LETTER OF OBJECTION

FG/116/18/HH 2 OCEAN DRIVE FERRING BN12 5QJ, OBJECTION LETTER AND PHOTOS

DRAWING BLOCK PLAN DATE: MAY 2018 DRAWN: T. Murray	SCALE 1/500
DRAWING: 18/28/3	REVISION:

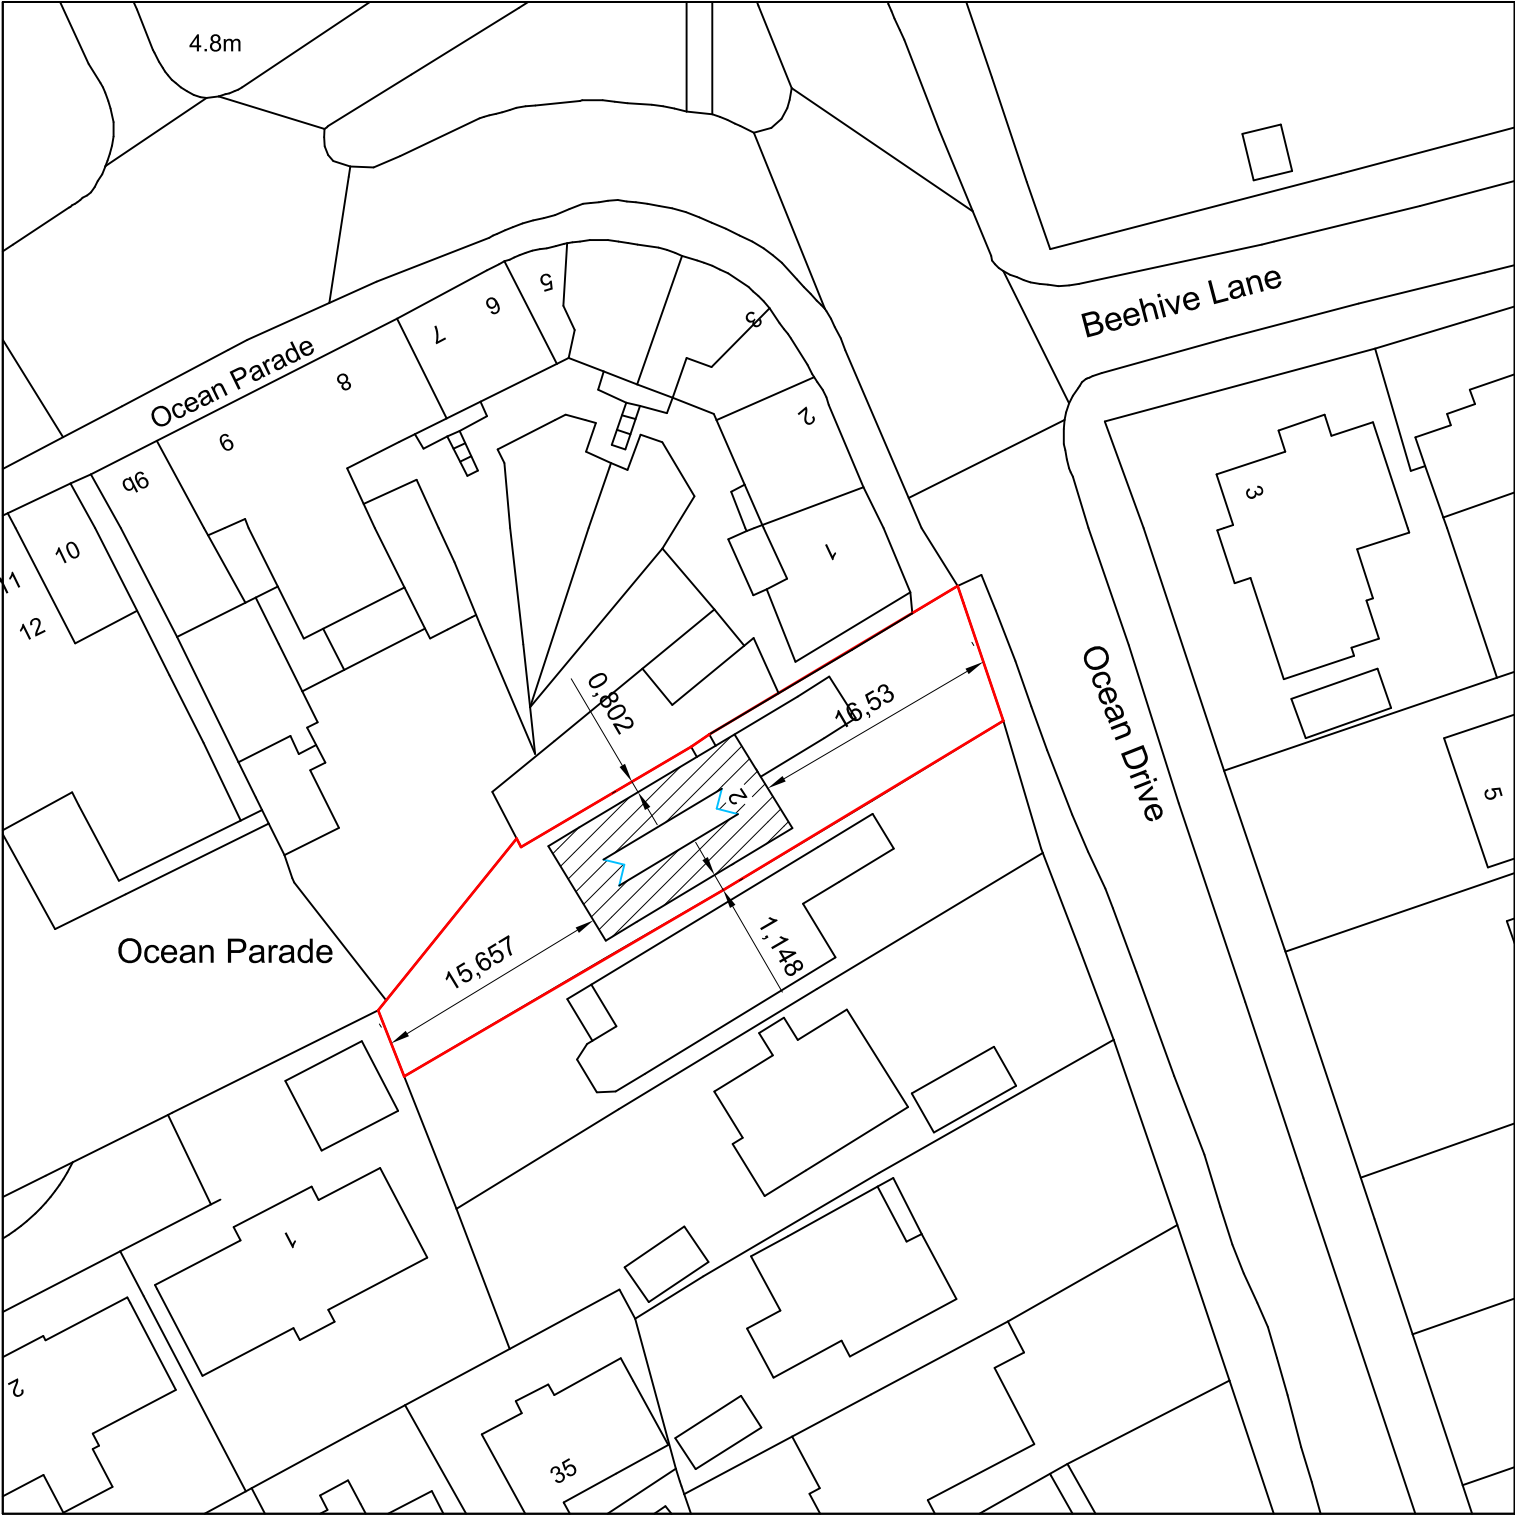
What is also not made clear in the plans is that the bungalow at 2 Ocean Drive is set a long way back from the road, meaning that the gardens of residential properties in Ocean Parade

are actually immediately adjacent to the bungalow at 2 Ocean Drive. As a result the plans are immediately placed into conflict with the properties and gardens of the residential properties in Ocean Parade, and number 1 and number 2 in particular, as the plans for the dormer roof for 2 Ocean Drive are directly in line with the gardens of Ocean Parade. The dominance of the plan is therefore overbearing and oppressive. It is an unneighbourly plan littered and fraught with serious technical mistakes, omissions, inaccuracies and flaws.

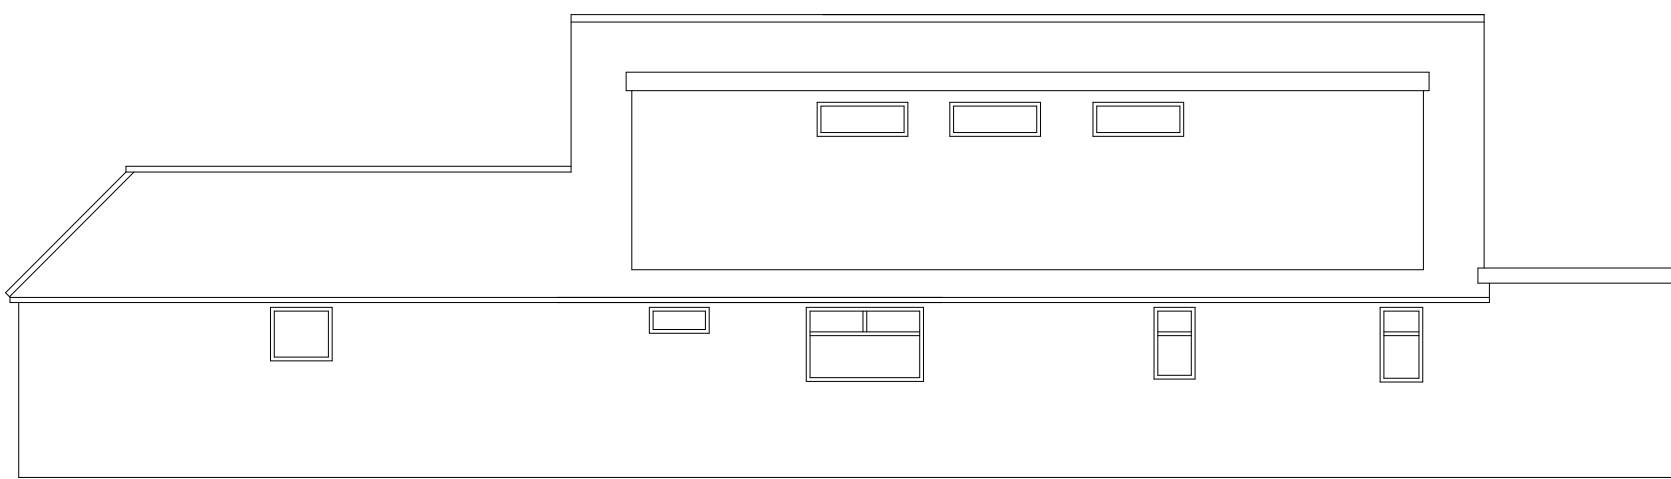
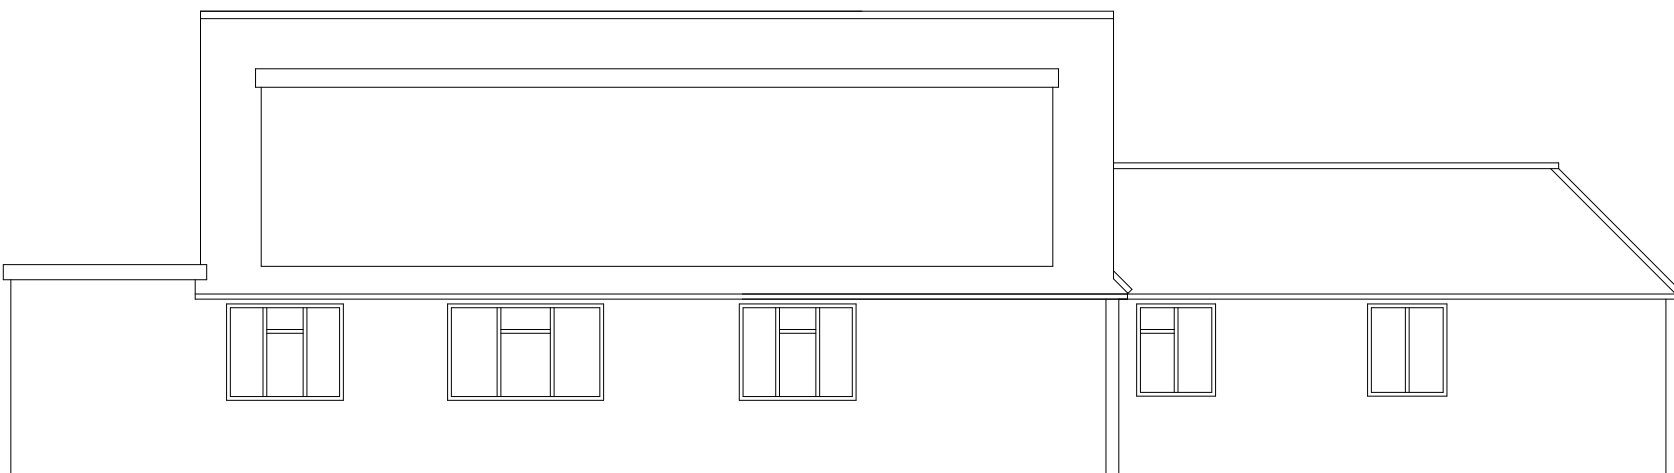
The height of the new roof increases the roof height up to a monumental one and half storeys high with overlooking windows, currently there are none. There is a distinct lack of boundary on both sides, the distance from the boundary on the North West elevation is very small, only 802mm. The location of the existing windows at 1 Ocean Parade and 4 Ocean Drive were strangely not made clear or taken into consideration in the plans and as a result these neighbours are seriously compromised to a huge extent. The dual aspect lounge windows in particular of the first floor apartment at 1 Ocean Parade were entirely ignored and the 45 degree rule has also been ignored. In addition the topography of the land has also been ignored and not taken into account and as a result it explains why when you look at the incredible scale of the dormer roof in the plans the towering size of it becomes even more apparent. This creates a tunnelling effect on the neighbours which is made worse by the fact that this plan builds all the way along the garden boundary line on the North West elevation, to the utter detriment on the neighbouring properties and gardens in Ocean Parade. It also creates a very bad tunnelling effect on 4 Ocean Drive.

My critic on the design is that aesthetically it is totally void of any finesse, attractive features and lines. This is an enormous industrial scale dormer. It is simply plonked on top of the existing bungalow on such a ridiculously large scale resulting in a complete imbalance in relation to the existing bungalow, the surroundings, the neighbouring bungalow at number 4 Ocean Drive and the quiet attractive mews style residential properties and gardens in Ocean Parade and the wider neighbouring area. This unneighbourly plan ruins and spoils the living conditions of neighbours, it takes away ambience, takes away light currently enjoyed and takes away privacy currently enjoyed by neighbouring properties and gardens but also and ironically it has a crushing negative result on number 2 Ocean Drive as well. It is a self-inflicted architectural own goal which will adversely impact on 2 Ocean Drive itself hugely. The plan, is ill conceived, it is over the top, unattractive, over kill, and a backward step, it will a blot on the landscape. In a day and age where the buzz phrase is “ environmentally friendly “ this the opposite, it rubs very abrasively against all aspects of this ideal and it is surprising that this plan has even been submitted. This plan is a retrograde step, it's old fashioned, dated looking in every way, it is not cool, it is going in the wrong direction, lacking in foresight, it results in something worse, something threatening and suffocating, something unpleasant and undesirable to be near or look at, resulting in the fact that it is not environmentally friendly in the slightest. Quite the reverse applies.
